**KIRKLEES METROPOLITAN COUNCIL
INVESTMENT & REGENERATION SERVICE**

Reference No:	2024/62/92008/E
Site Address:	5, Mead Way, Highburton, Huddersfield, HD8 0TG
Description:	Erection of front and rear extensions and alterations
Recommending Officer:	Edward Cheseldine

HOUSEHOLDER DELEGATED REPORT

North East Elevation
(rear)

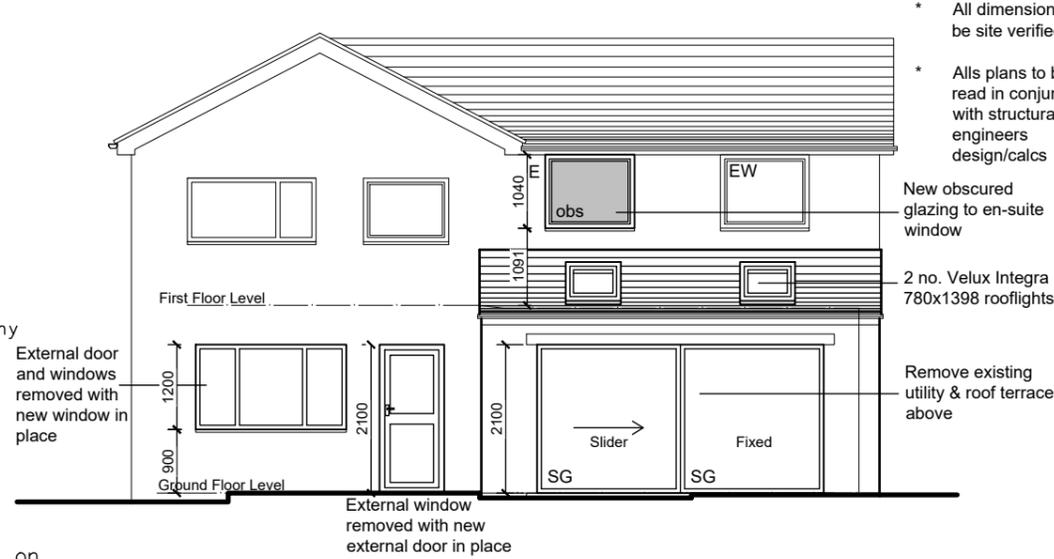
<u>Yes - COMPLY</u>	<u>No - JUSTIFY</u>
Be in keeping with the scale and style of the original house	<p>The rear extension will be 5.60m(w) x 2.85m(d) with an eaves height of ~2.50m. The rear extension will have a mono-pitched roof with two skylights installed. On the rear face will be two large rear windows.</p> <p>The extension is modest in scale, retaining a significant proportion of the original rear elevation.</p> <p>Although the windows are large, modernist dwelling often contain large openings, therefore the character of the dwelling will be retained.</p>	
Not normally cover more than half the total area around the original house (including	Yes, the rear extension is modest in scale.

There are other external alterations, including the removal of the front bay window which will be replaced by flush Upvc windows, the replacement of a rear window, the opening will be widened, in addition an obscurely glazed window will be installed on the rear of the first floor replacing the Juliet balcony. The modifications are modest. Although the front bay window is a characterful element of the frontage, the installation of the canopy will provide an architectural feature that provides a similar impact in terms of visual amenity.

Summary of Representation	Officer response	Addressed ✓ / X / N/A
The single-story rear extension should not have a balcony. This would overlook my back garden, and could lead to noise problems.	The balcony has been removed under the proposed plans. It would be replaced by a lean-to roof.	✓

4. The development shall not be occupied until the W/C window in the rear elevation of the building hereby approved has been obscurely glazed (to a minimum Grade 4). Notwithstanding the provisions of the Town and Country Planning (General Permitted Development) Order 2015 as amended (or any Order revoking or re-enacting that Order) the obscure glazing (to a Grade 4) shall thereafter be retained.

South West Elevation
(front)

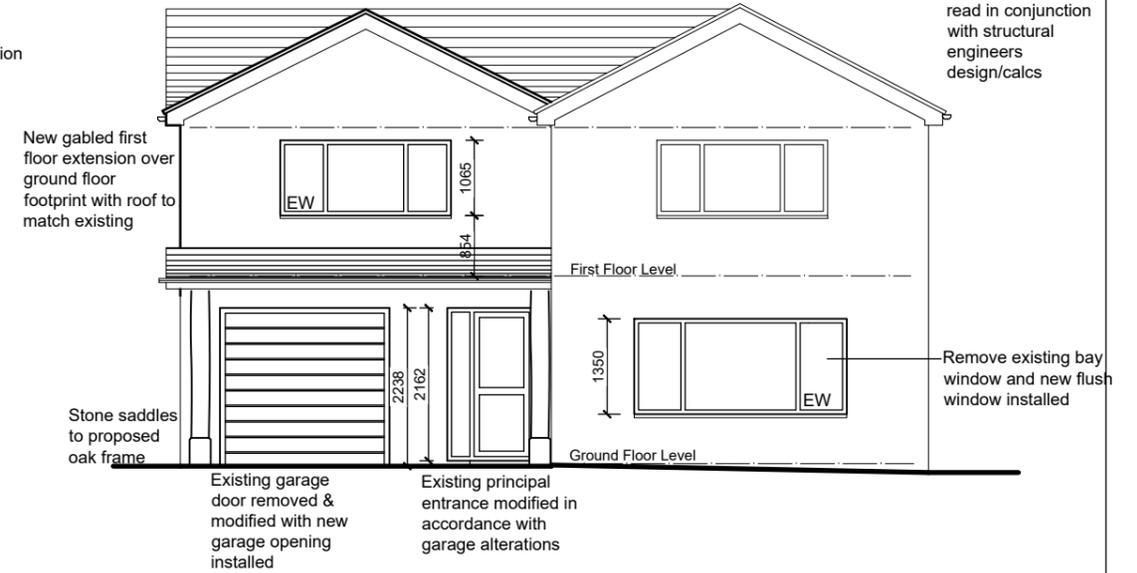
YES / NO	SUMMARY
Negotiations/Amendments during course of application	Yes	In order to break-up the front elevation and to assimilate the extension within the wider building group, it was requested that a architectural feature was added to the principal elevation. A lean-to canopy was added to the plans.
